**Re: Status of Improvement Permit Application #5-5-11320  
Lot 89 Woodshire**

**Re: Status of Improvement Permit Application #05-5-11320  
Lot 89 Woodshire**

PROPOSED HOUSE LOCATION

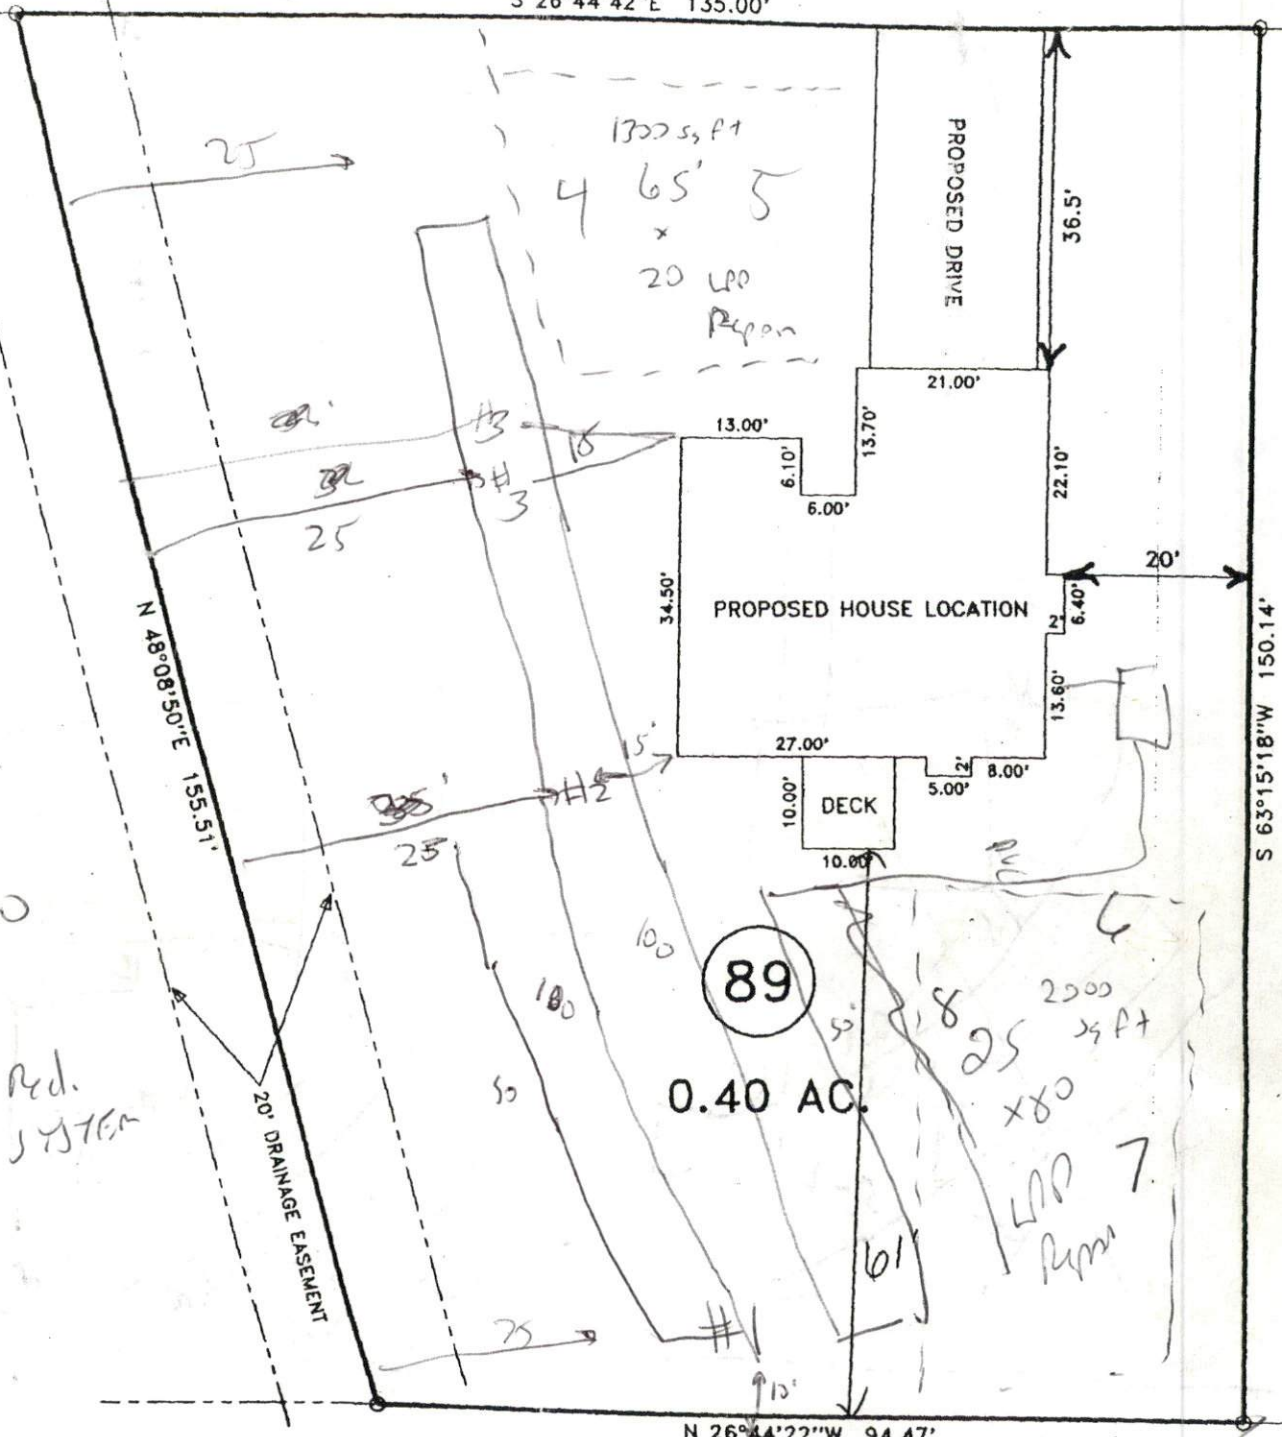
- 1. Property lines/corners not marked or labeled
- 2. House corners not marked or labeled
- 3. Directions not clear to property
- 4. Property needs brush or vegetation removed
- 5. Backhoe pits required
- 6. Other **Change house location as shown.**
